# CITY OF ALBUQUERQUE

RE: **Parking Lot for 6<sup>th</sup> St/Fruit Ave**  
**6th St/Fruit Ave**  
**Grading and Drainage Plan**  
**Engineers Stamp Date 8/4/15 (J14D177)**

Based upon the information provided in your submittal received 8/4/15, this plan cannot be approved for Grading Permit or Paving Permit until the following comments are addressed.

ENGINEER'S SEAL 8/4/15 DAVID SOULE P.E. #14522	PARKING LOT FOR 6TH ST AND FRUIT AVE. GRADING AND DRAINAGE PLAN Rio Grande Engineering 1808 CENTRAL AVENUE SUITE 201 ALBUQUERQUE, NM 87106 (505) 872-0888	DRAWN BY DEM
		DATE 7-15-15
		SHEET # 2 of 3
		JOB # XXXXX

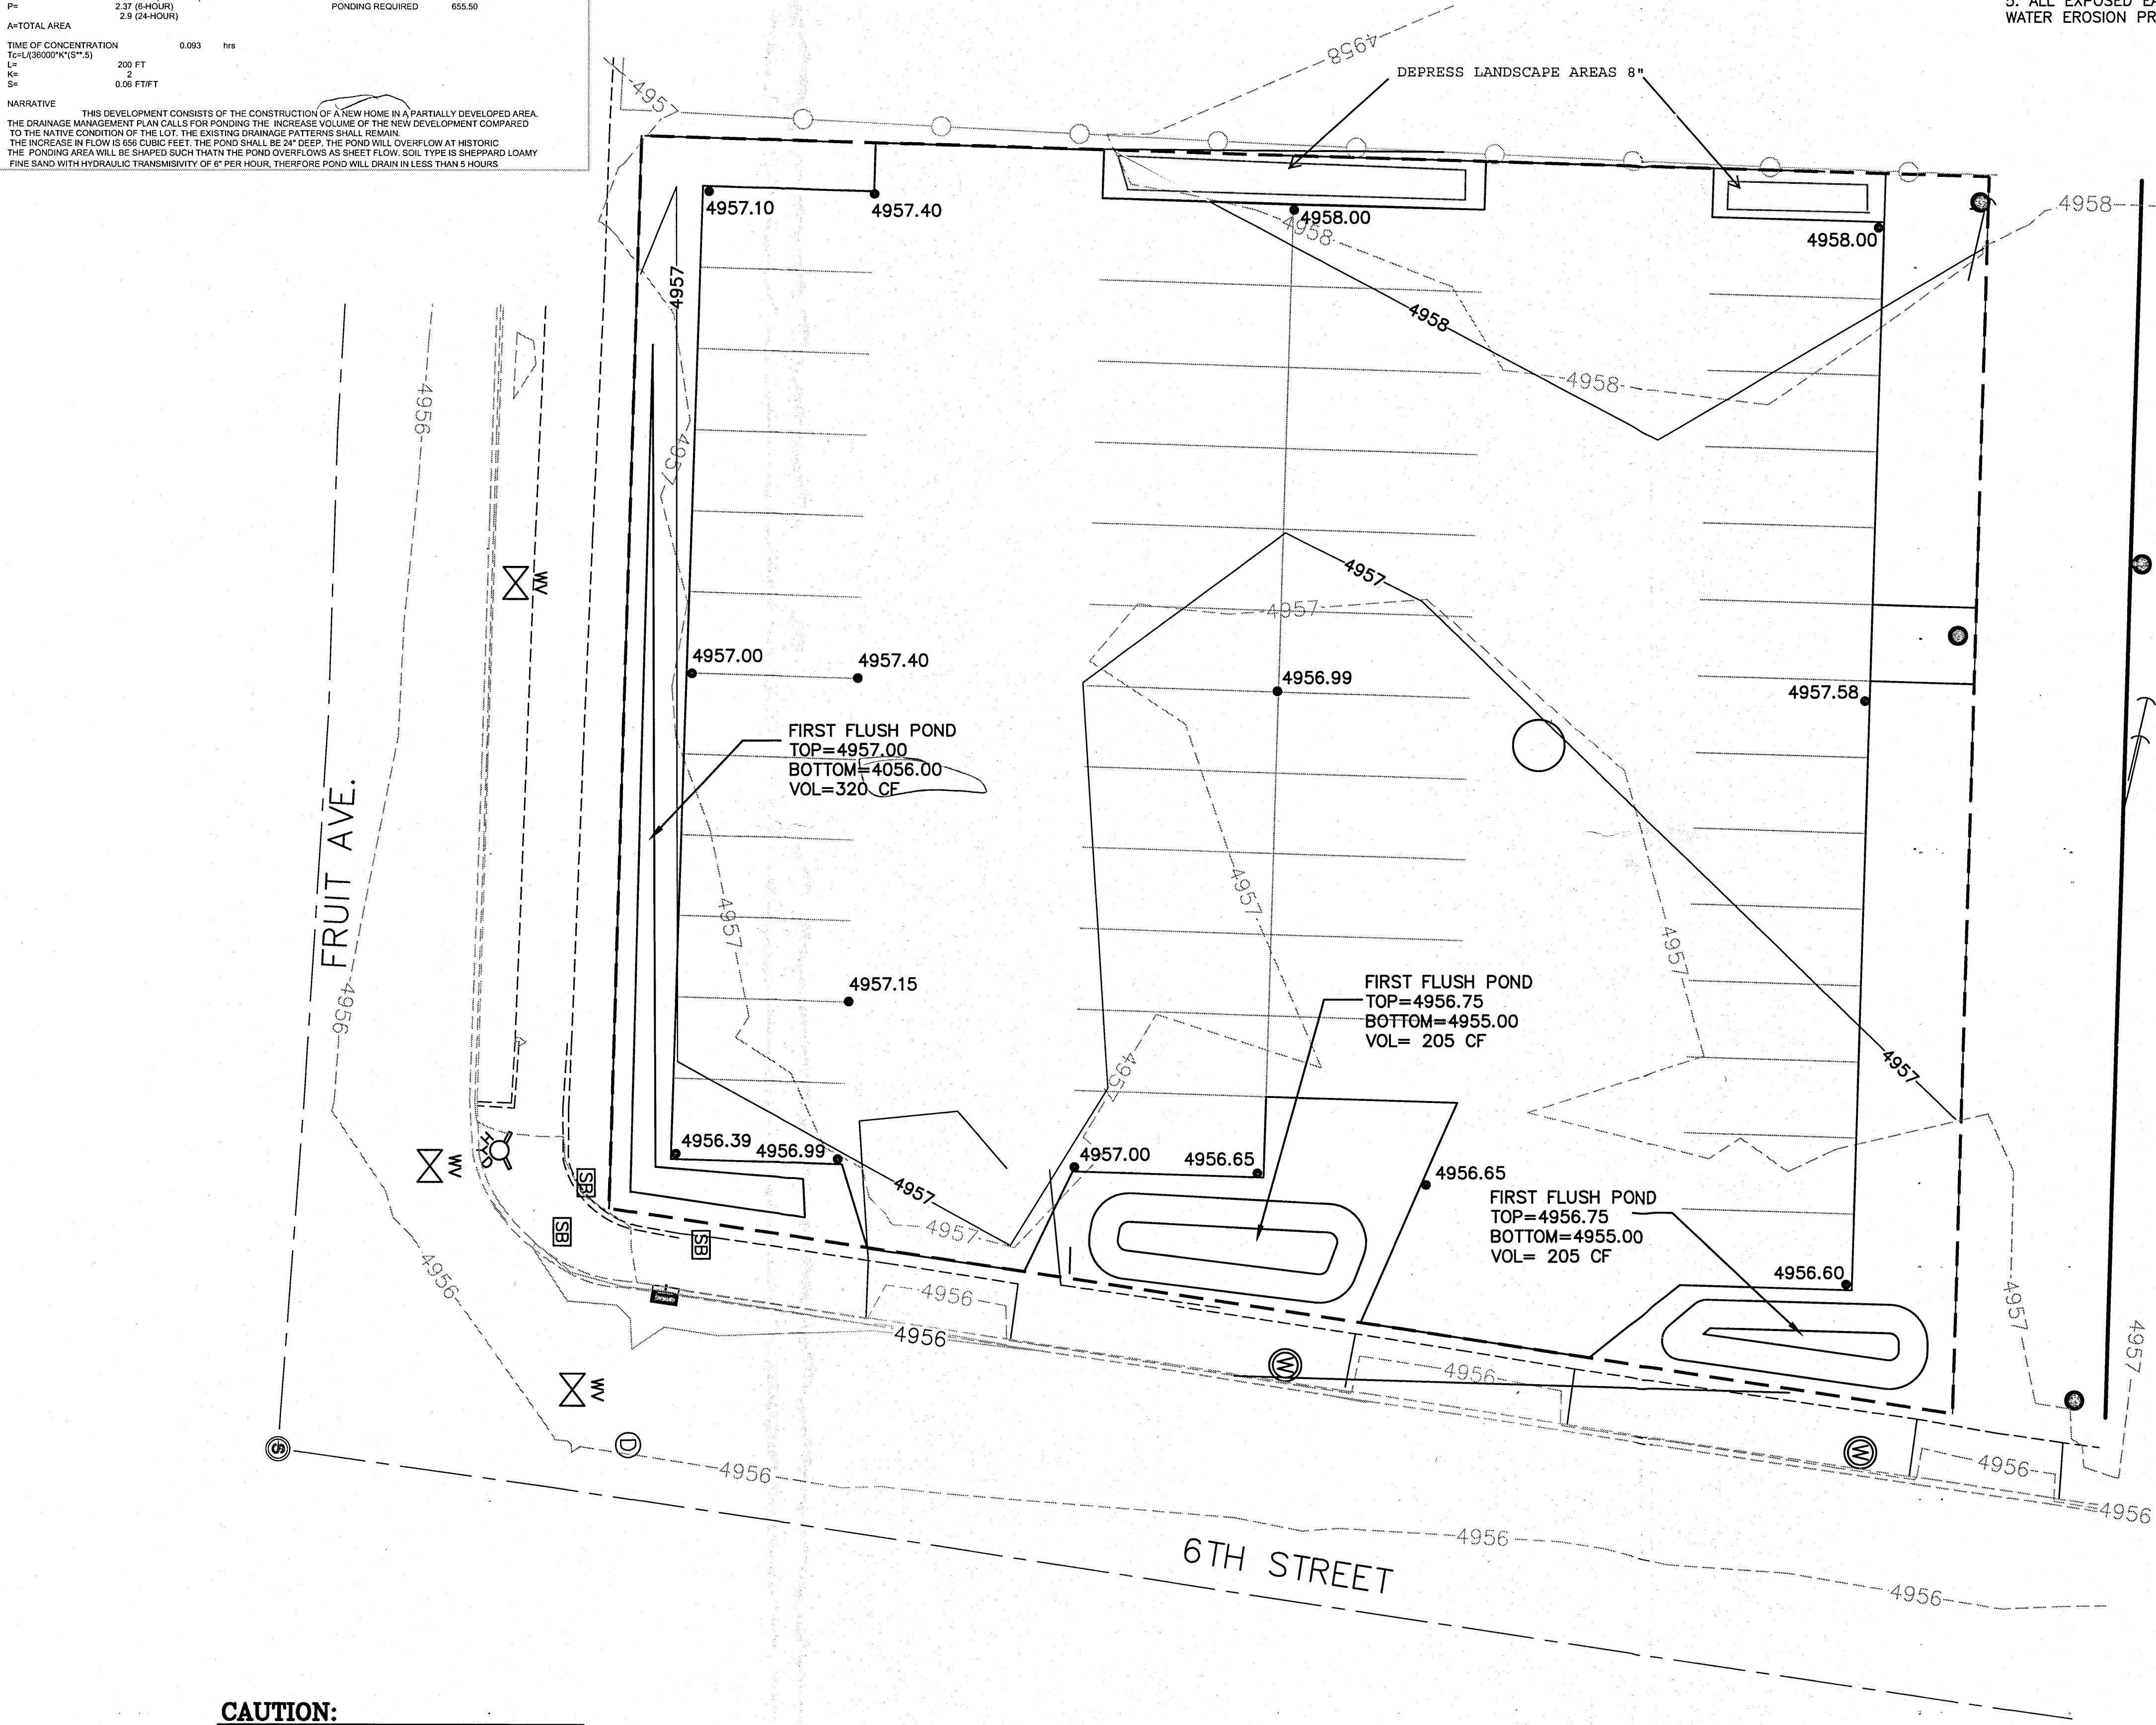
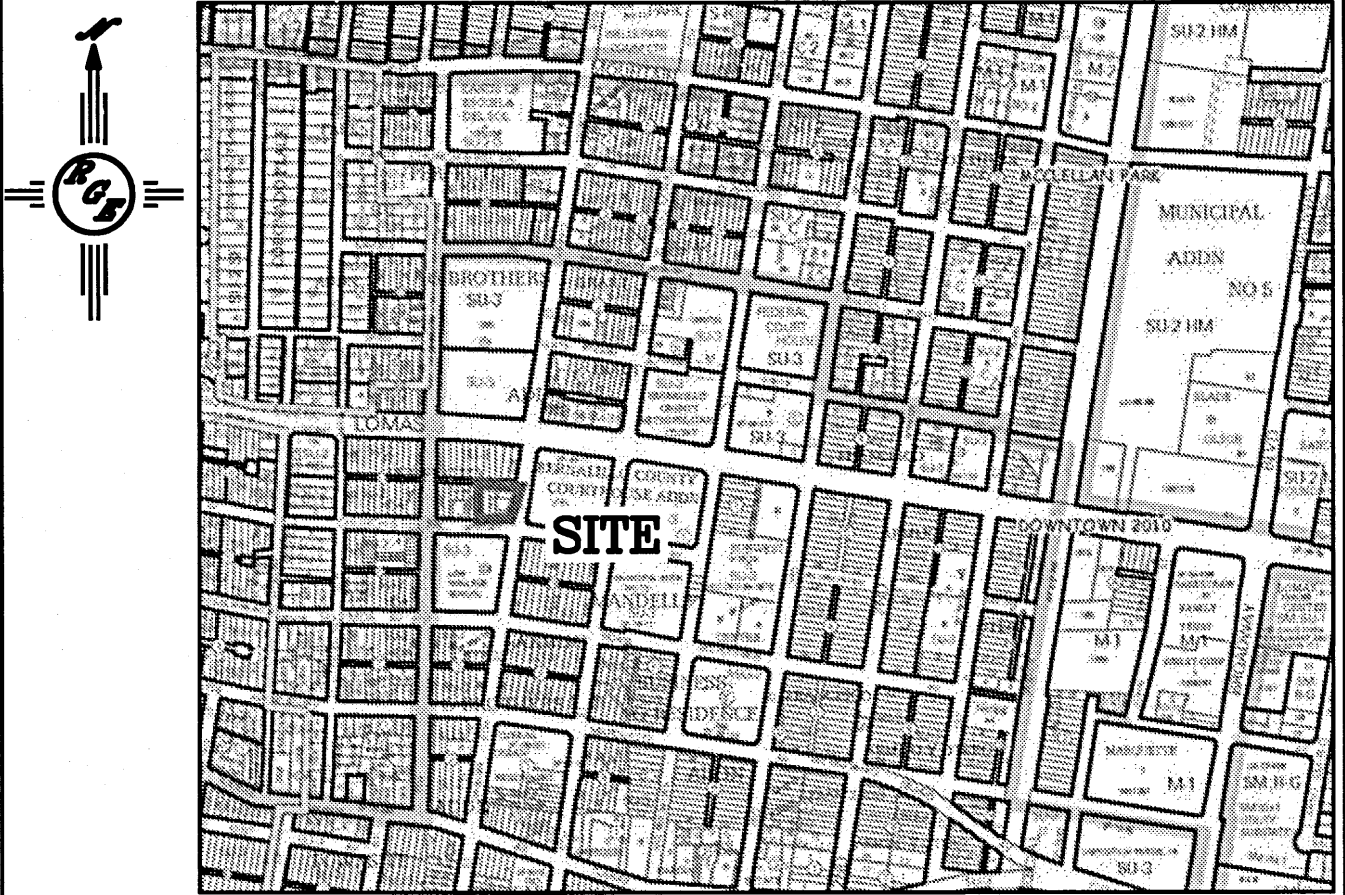
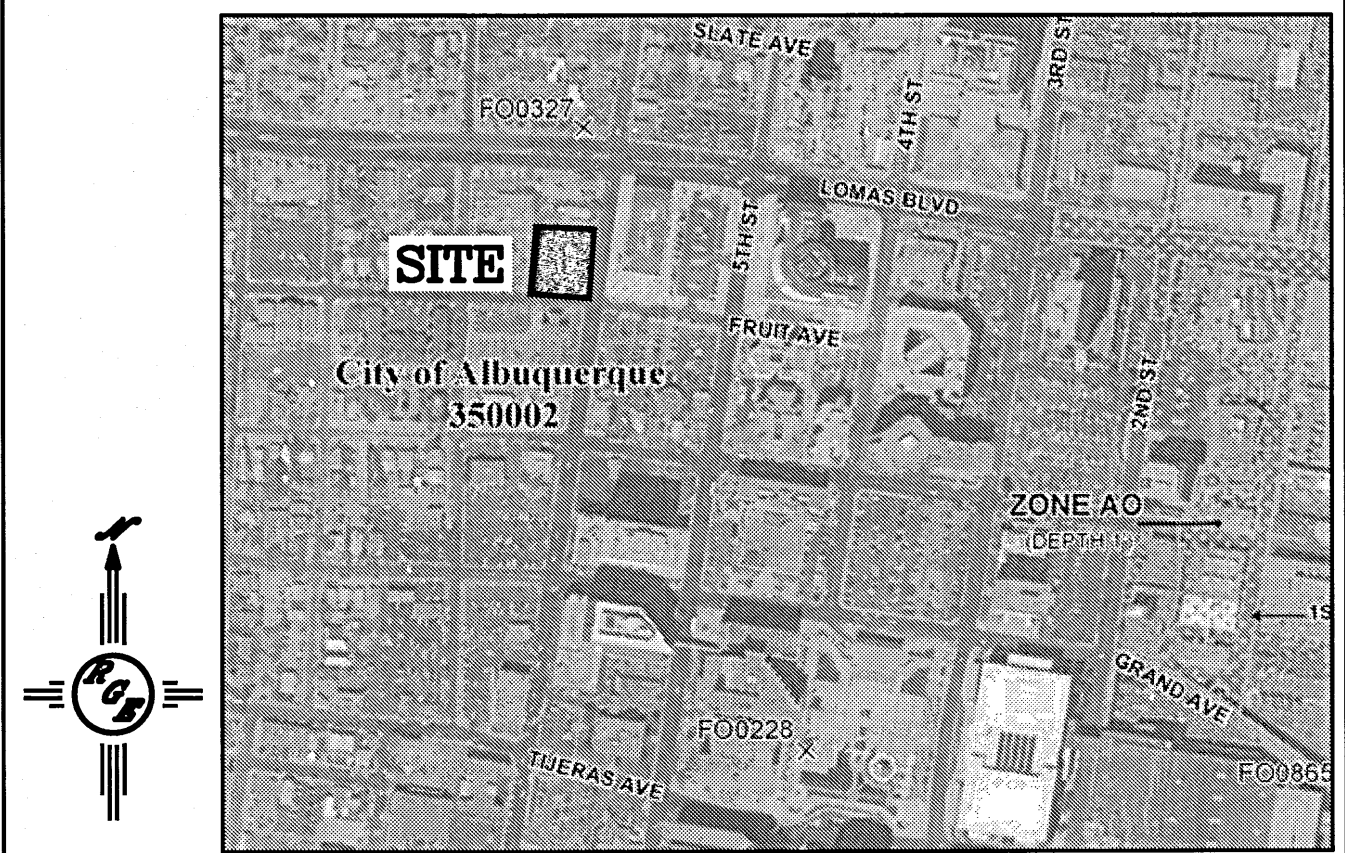
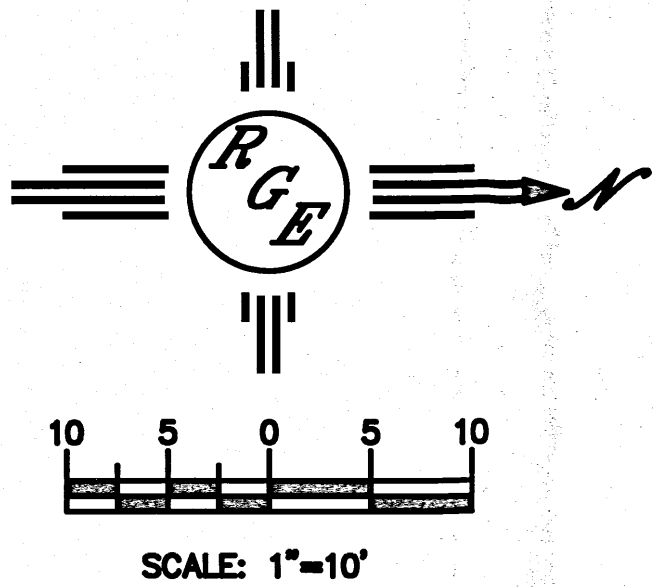
- Provide a larger font for the Drainage Calculation Sheet. ~~Not complete~~
- In the narrative a new home being built is mentioned. Where is the home located in this parking lot? ~~Not answered~~
- The first flush pond to the south shows a TOP = 4957.00 and a BOTTOM = 4056.00, I hope this is a typo, adjust accordingly. ~~Not answered~~
- The three ponds to the east have a TOP shown larger than the spot elevation provided next to the ponds, adjust accordingly. ✓
- Is the lot being paved, or kept as is? Are parking bumpers supplied? The alley will need to be paved. A TCL is required. ~~Not answered~~
- Provide the benchmark. ~~Not answered~~
- How will erosion, dirt, dust from the parking lot be kept out of the right of way (6<sup>th</sup> St.)? ~~Not answered~~

- Provide a larger font for the Drainage Calculation Sheet. **ADDED**
- In the narrative a new home being built is mentioned. Where is the home located in this parking lot? **CORRECTED**
- The first flush pond to the south shows a TOP = 4957.00 and a BOTTOM = 4056.00, I hope this is a typo, adjust accordingly. **CORRECTED**
- The three ponds to the east have a TOP shown larger than the spot elevation provided next to the ponds, adjust accordingly. **CORRECTED**
- Is the lot being paved, or kept as is? Are parking bumpers supplied? The alley will need to be paved. A TCL is required. **INCLUDED TCL**
- Provide the benchmark. **ADDED**
- How will erosion, dirt, dust from the parking lot be kept out of the right of way (6<sup>th</sup> St.)? **INCLUDED LANDSCAPE PLAN TO SHOW GRAVEL**
